**Town and Country Planning Act 1990
Application for Permission to Develop Land**

Response from Pollution & Noise Control

PNC Reference No:	WK/201615471
Name of Planning Officer dealing with the matter:	Farzana Tabasum
Application Number:	2016/92298
Proposed Development:	Outline application for re-development of former waste water treatment works following demolition of existing structures to provide employment uses (use classes B1(c), B2 and B8) and residential use (use class C3)
Location:	North Bierley Wastewater Treatment Works, Bradford Road, Oakenshaw, Bradford
Date Required By Planning:	5th August 2016

ILLUSTRATIVE MASTER PLAN

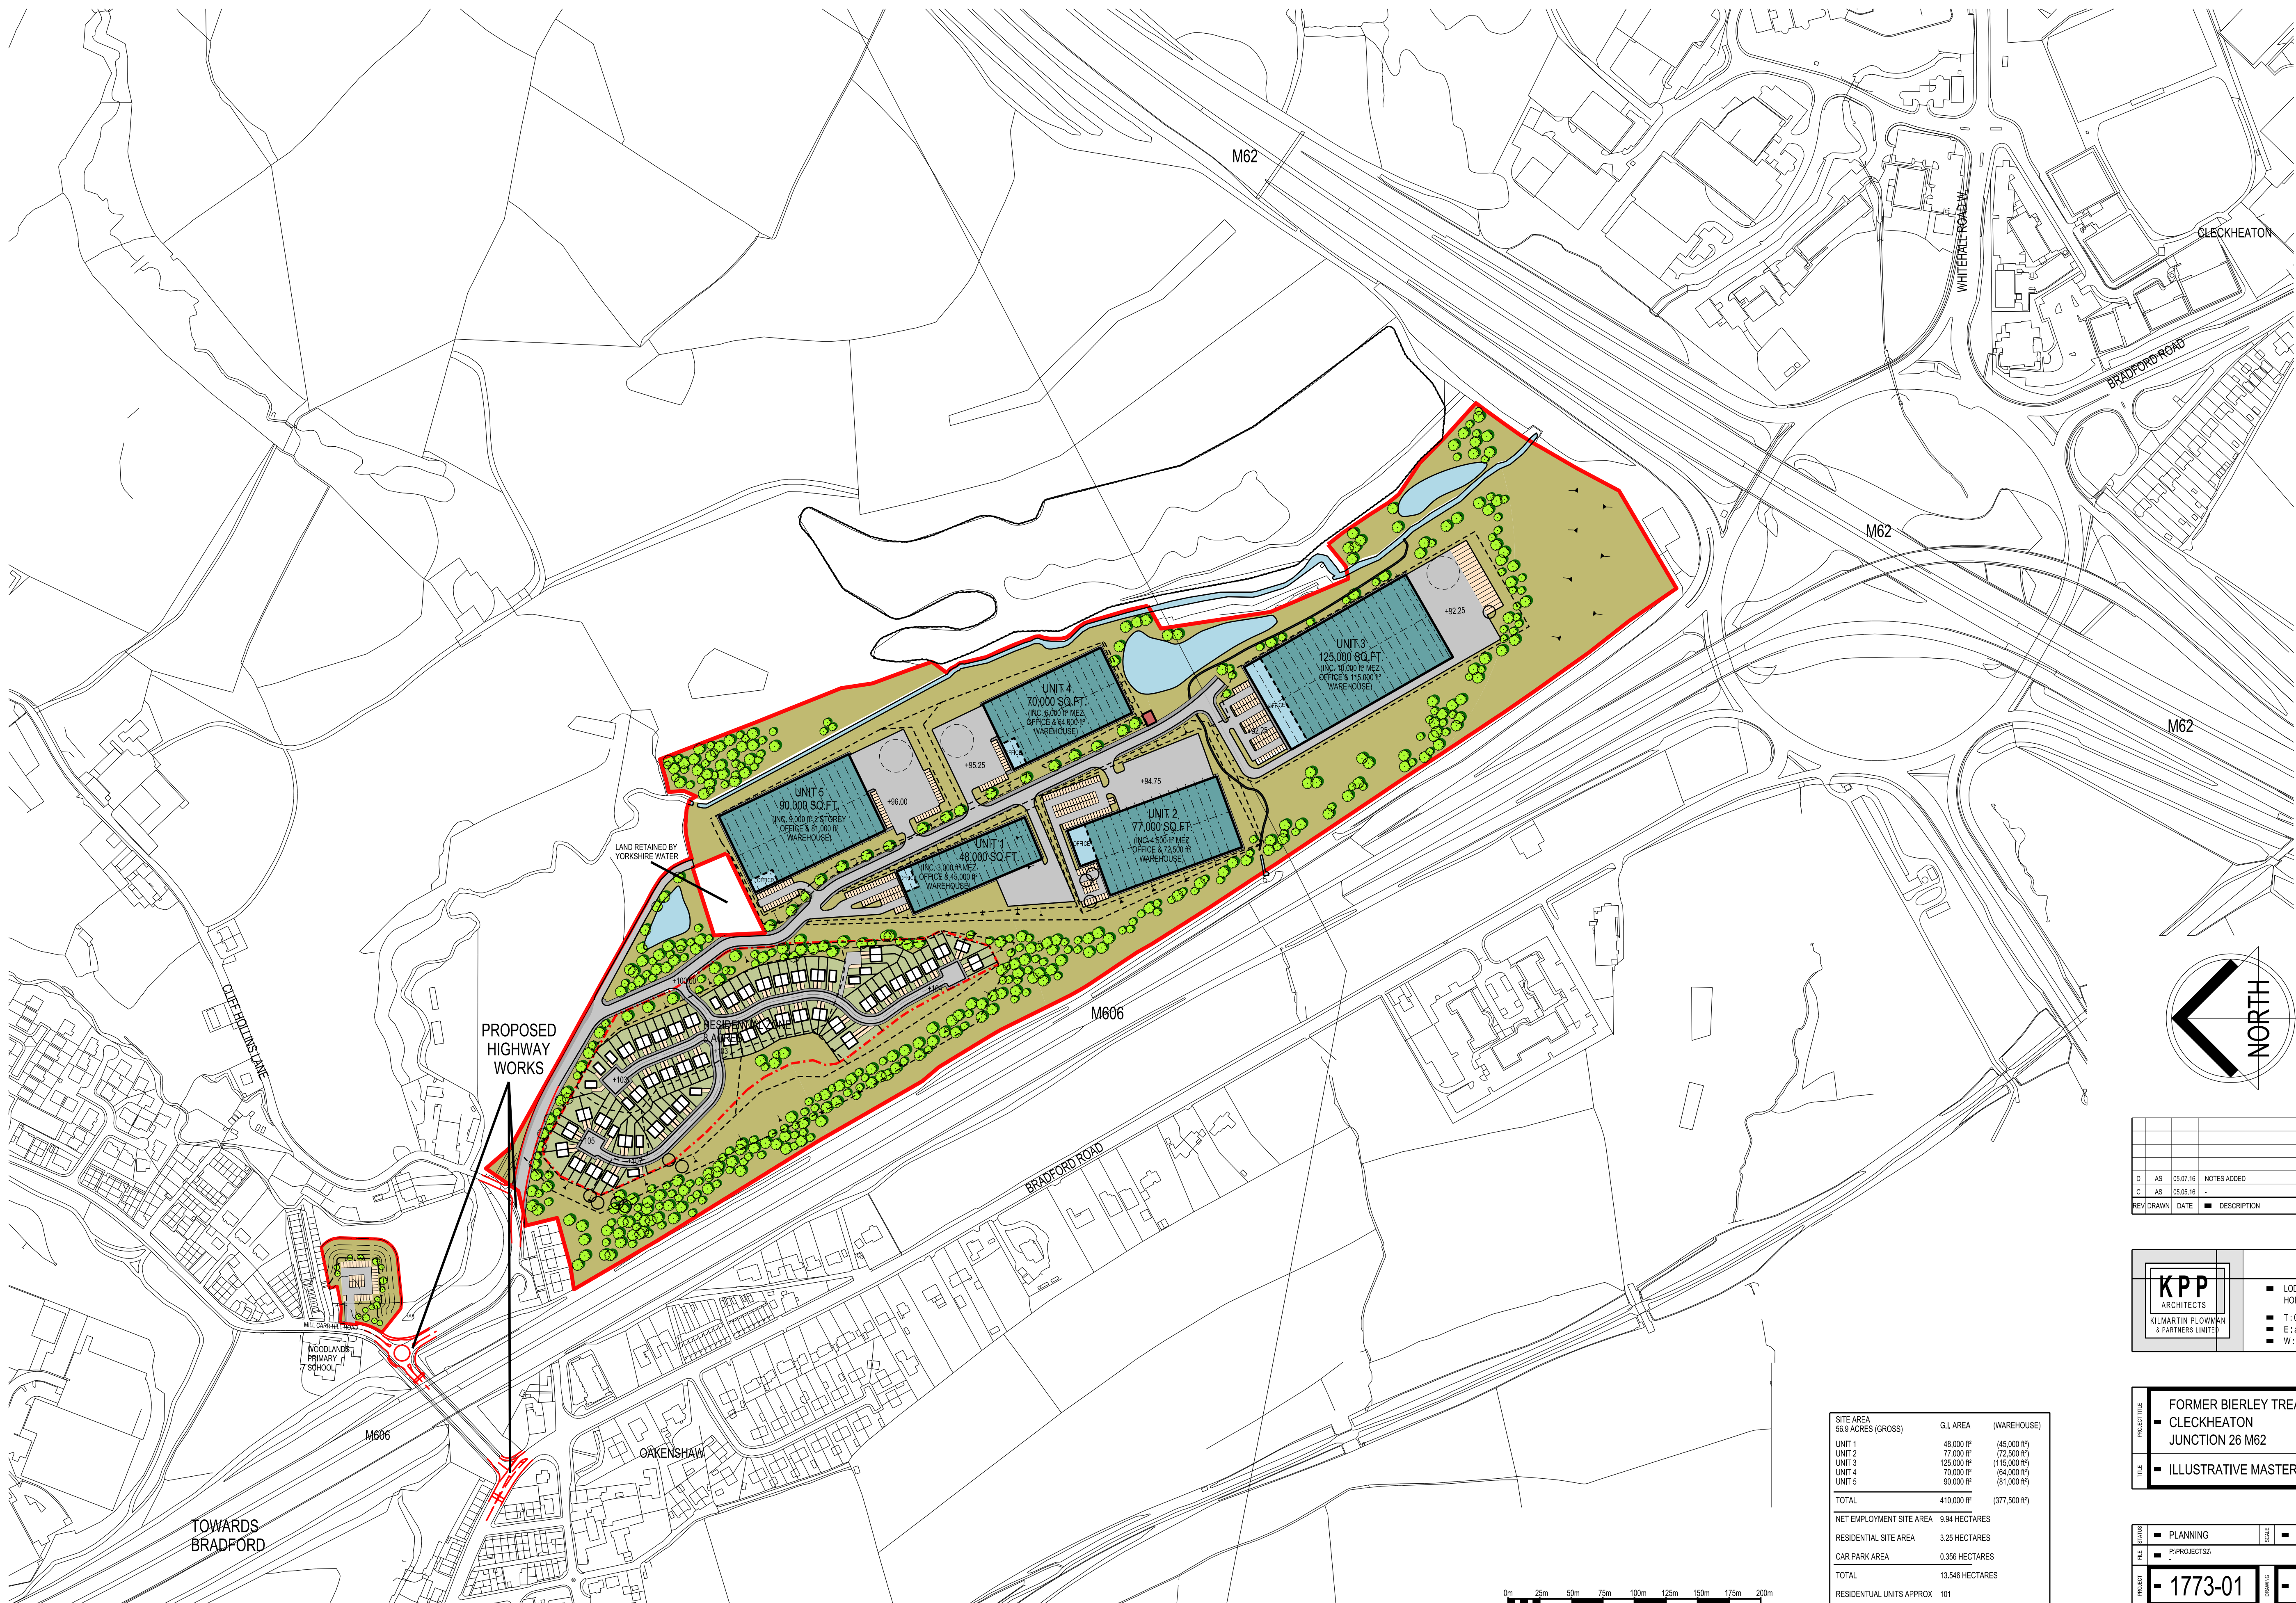
The proposed development introduces noise sensitive residential properties to an area that is close to the M606, these residential properties are likely to be significantly adversely affected by road traffic noise.

Part of the application is for new commercial uses, and some of these are in close proximity to some of the proposed residential properties. There is a strong potential for noise from these commercial uses to adversely affect the residential properties.

The access road to the proposed new commercial premises passes close to many of the proposed residential properties. This could also result in road traffic noise, particularly from

heavy goods vehicle movements throughout the night, adversely affecting the occupiers of the residential development.

I consider that the potential impact of noise from road traffic and the proposed commercial part of the development makes residential part of this development is far from ideal. The proposed dwellings will be very close to the significant road traffic noise from the M606. They will be in close proximity to the proposed commercial part of the development. They will also be very close to the vehicle access route into the commercial part of the development.

The proposal to place B1, B2 and B8 uses in close proximity of to the residential properties is considered likely to result in ongoing noise issues. The long term future occupiers of the commercial development cannot be predicted and could result in some noisy activities and/or used that generate very high levels of HGV movements potentially throughout the night. Noise at night from the commercial part of the development and vehicles accessing it could be controlled by placing an hours of use restriction on this part of the development but that would be reduce the viability of the commercial development.

I consider that the proposed residential part of the development is not an appropriate use of the land due to the high noise levels from road traffic noise from the M606 and also potential noise from the commercial part of the development and road traffic noise from the access road leading to it, and also potentially from possible alterations to the nearby M62 junction.
